MEMORANDUM

To: FILE
From: Nell Donaldson
Subject: Application ID: 2013-179
Date: 8/1/2013

To: Nell Donaldson
Barbara Barhydt
From: David Margolis-Pineo
Re: Review Comments – Bayhouse II – 40 Hancock Street

**TREE PIT DETAIL**  
NOT TO SCALE

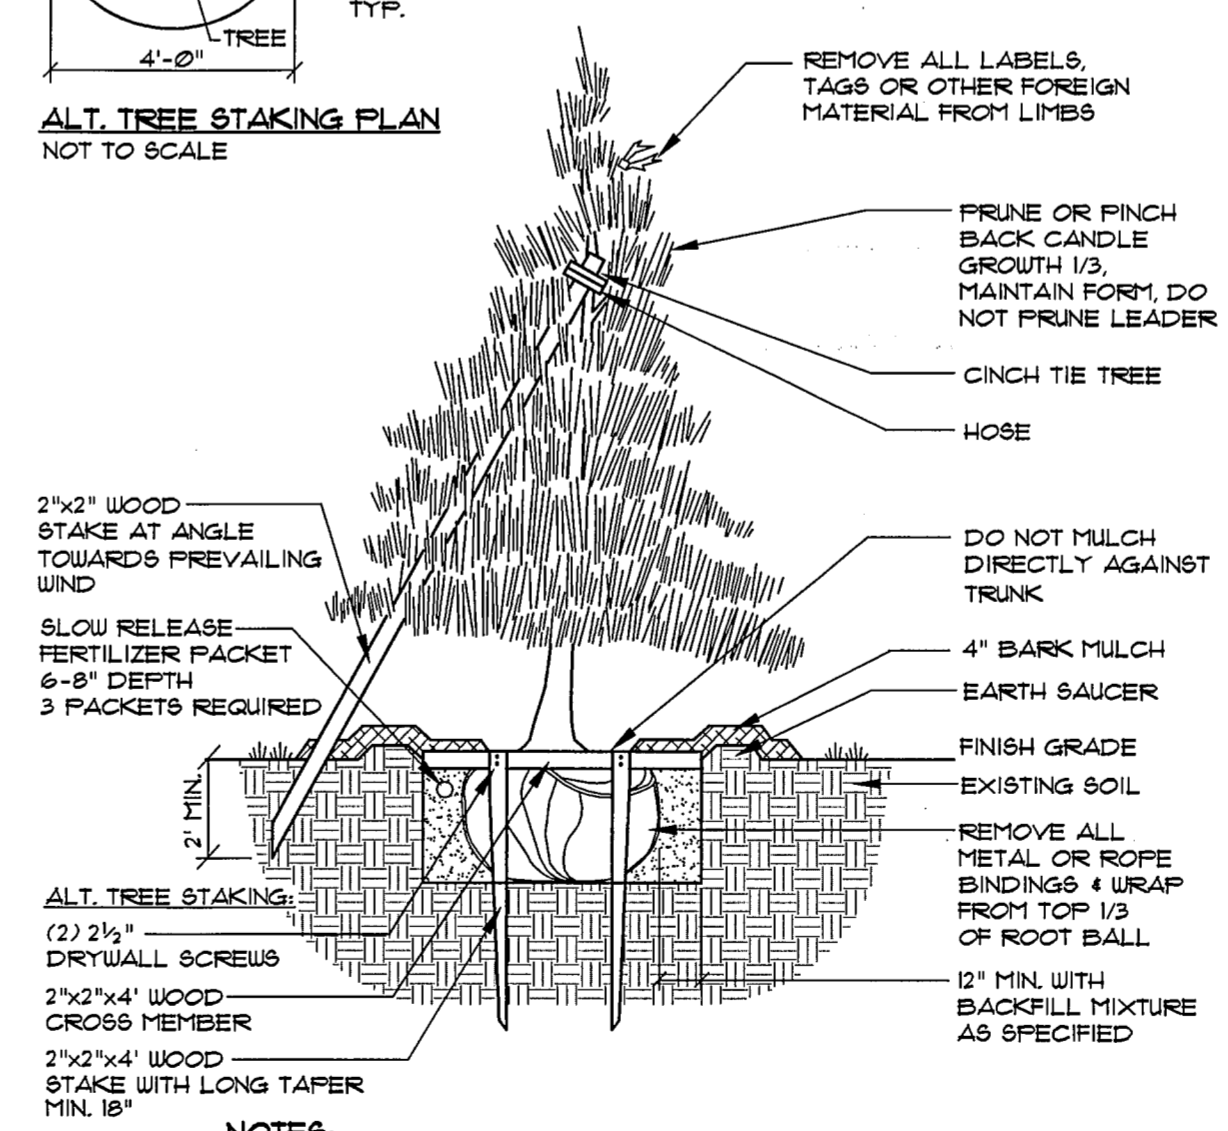
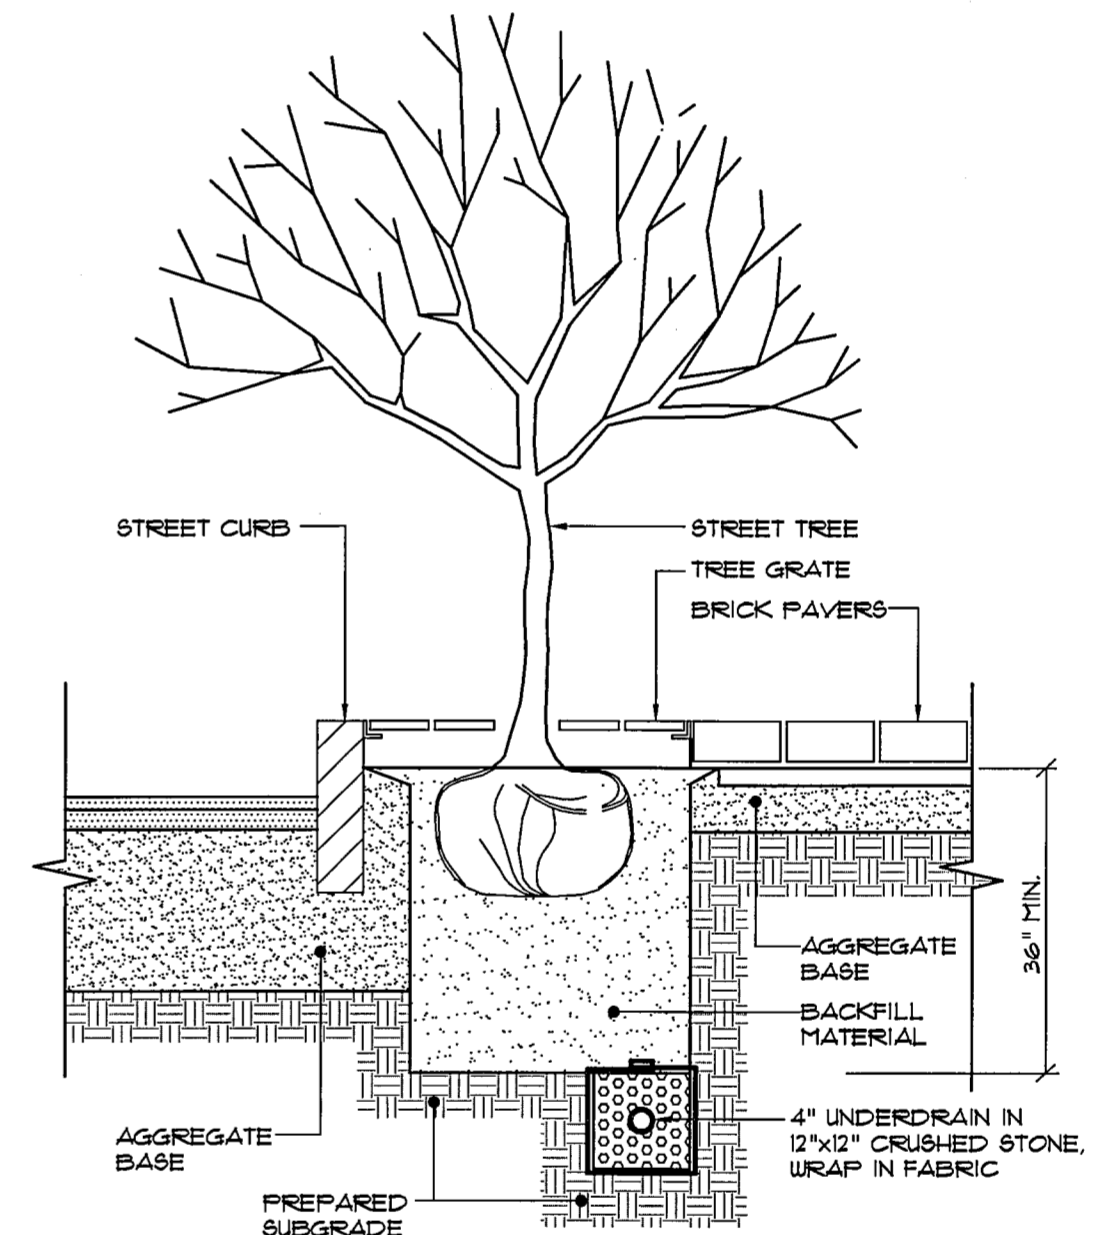
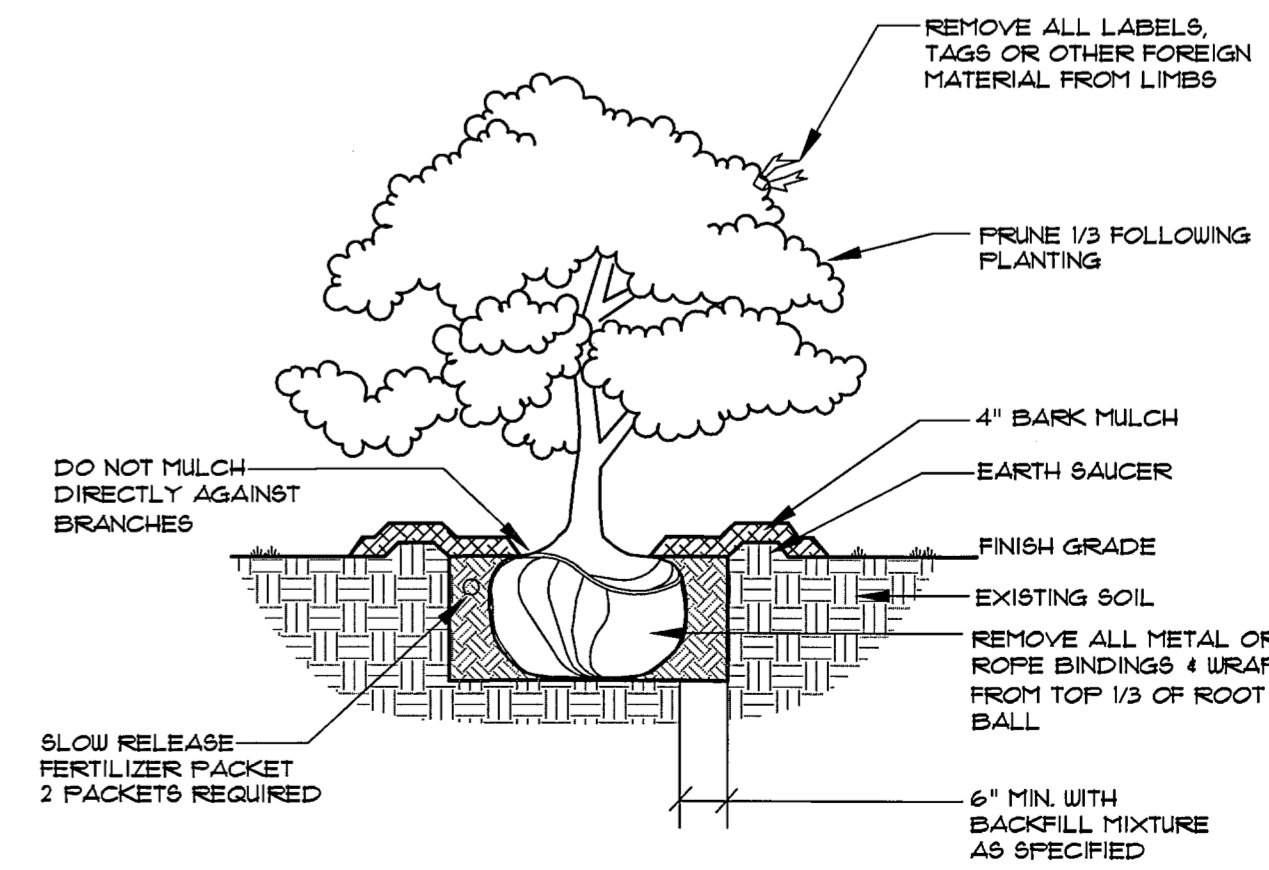
Street trees - would like to review the tree pit planting details, tree grates?

SHEET 2 OF 14

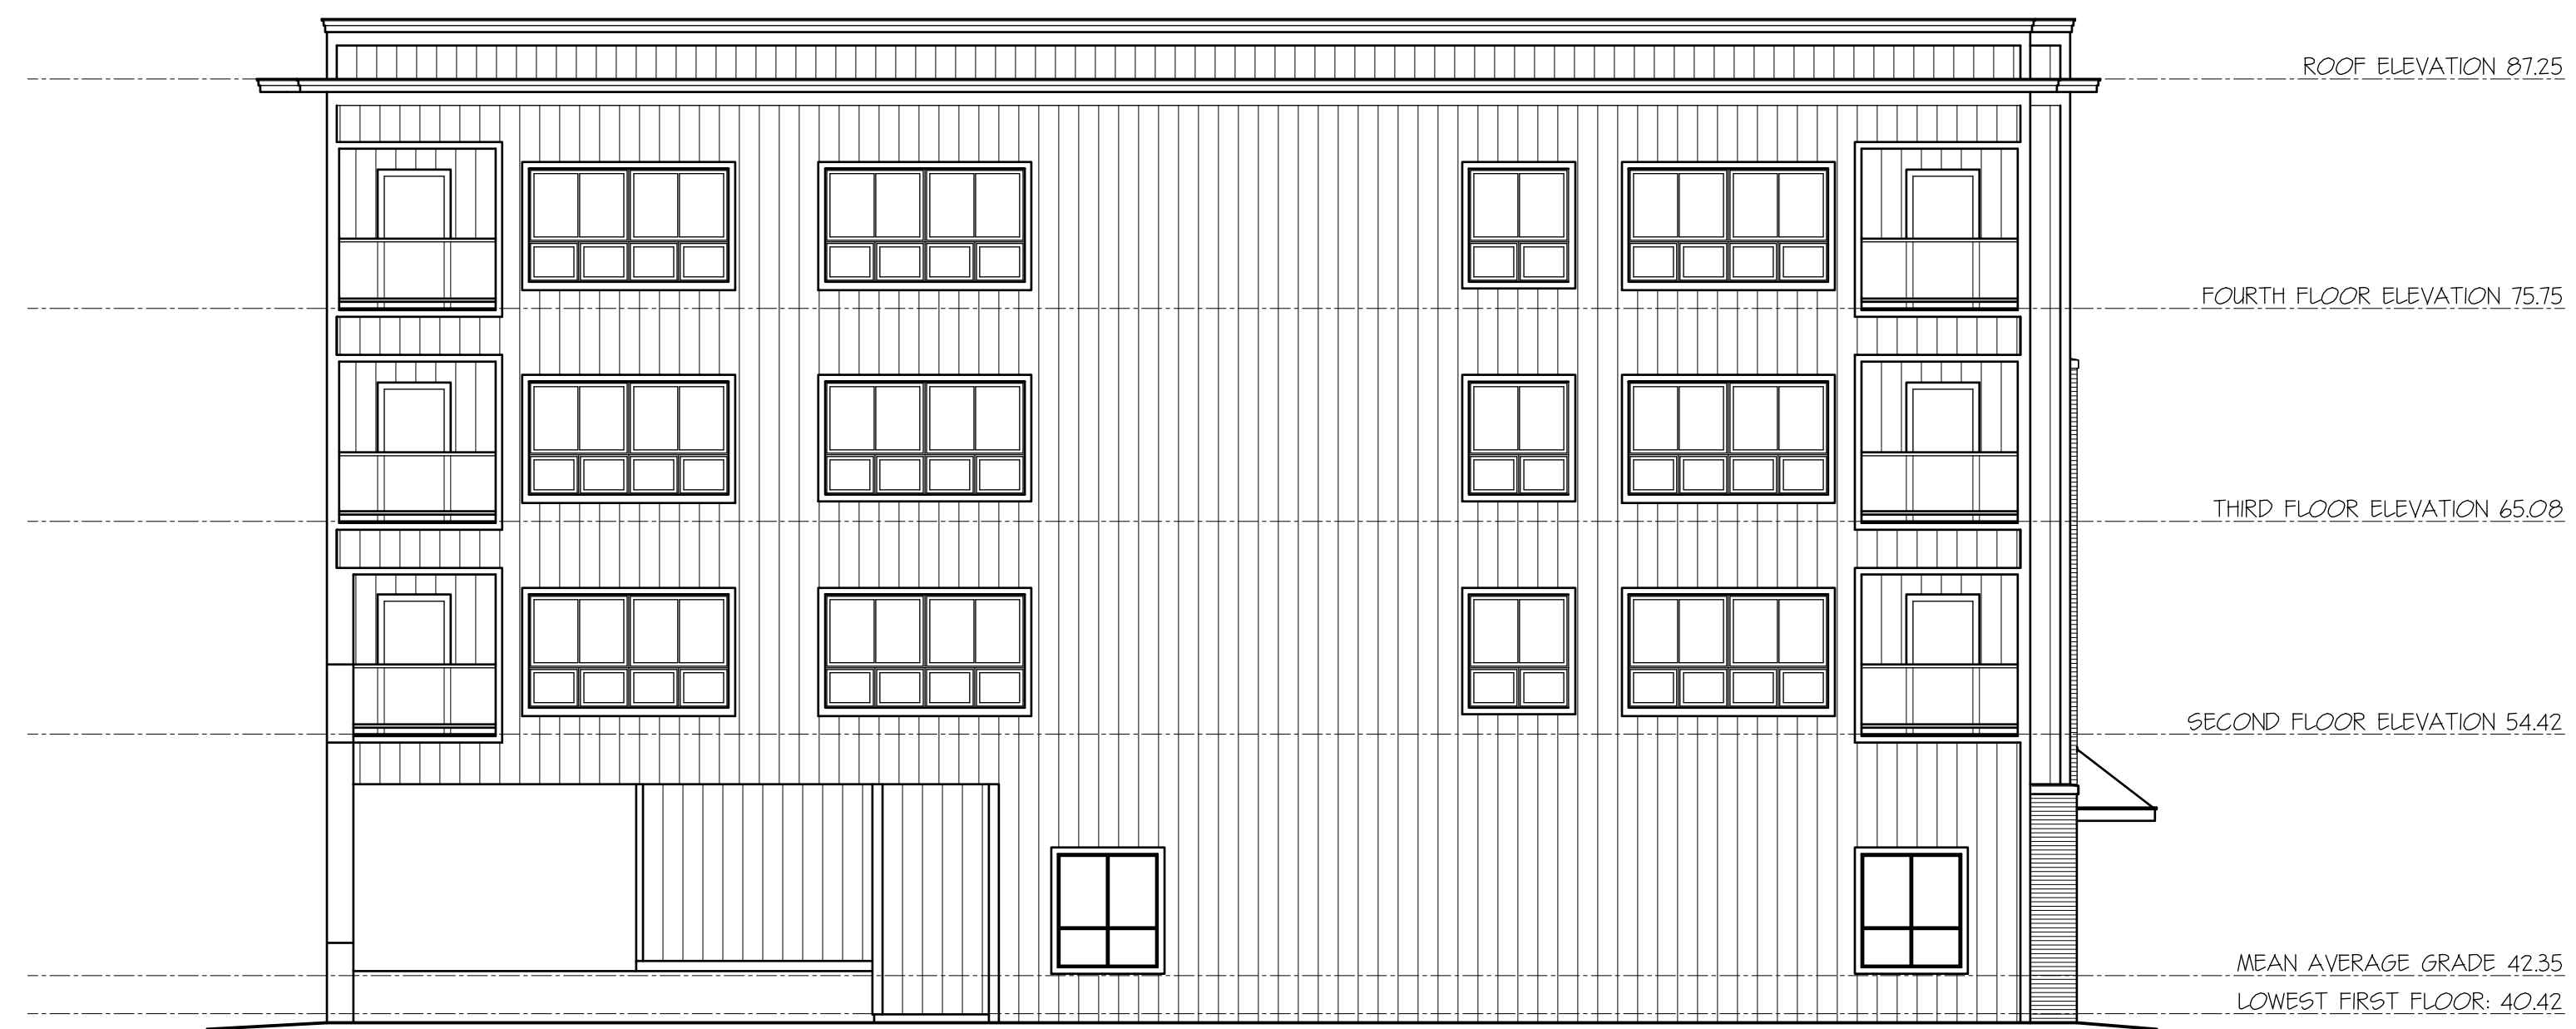
7. Sheet 2 of 12 submitted with the Phase II project dated 7-26-13 does not match Sheet 1 of 1 submitted on 7-13-13. Please clarify and re-submit.
8. All submitted plans require a Professional Engineer’s stamp.

**SHEET 5 OF 14**

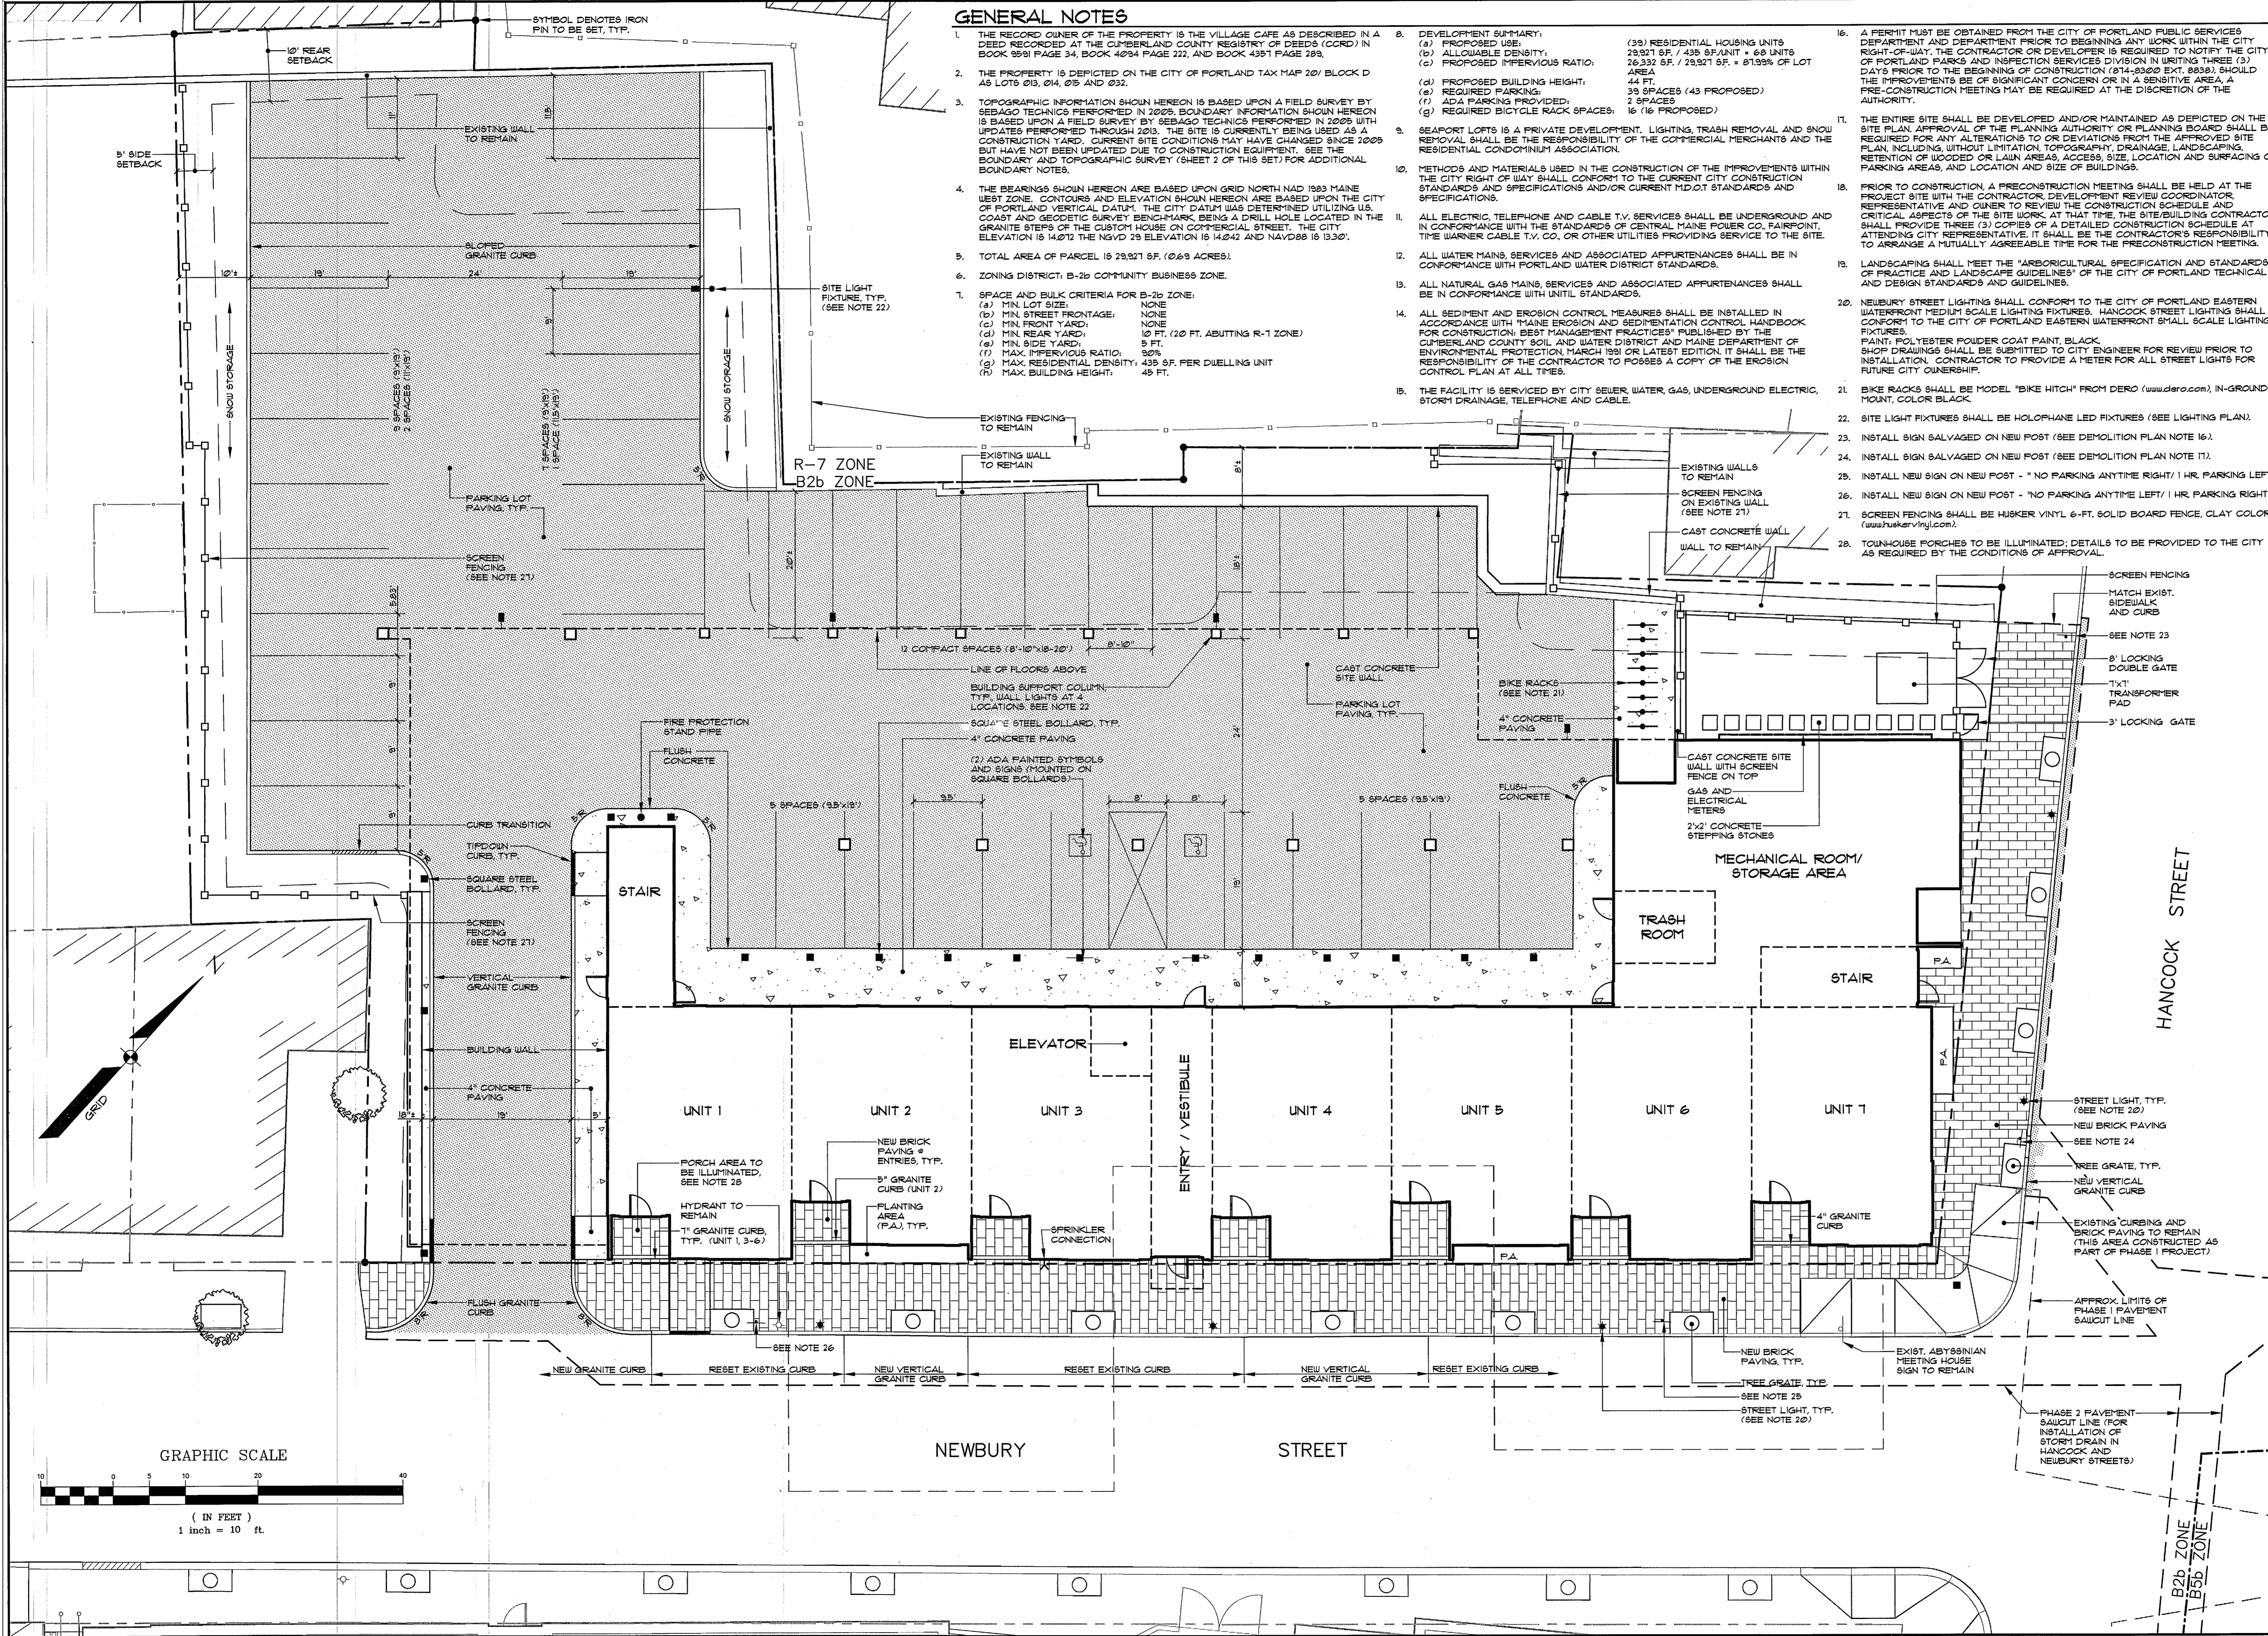
I have reviewed additional plans down loaded into our system on 7/29/2013. On page 5 of 12 there is a note that shows how the project is meeting the impervious surface maximum of 90%. The given lot size on this sheet (30,282 sf) is different from the filled out site plan data sheet which states the lot size is 30,492 sf. The proposed given impervious surface is different again in the same two locations. I would want the applicant to confirm the actual lot size and the final proposed impervious area on the site so I can determine compliance with the Ordinance.
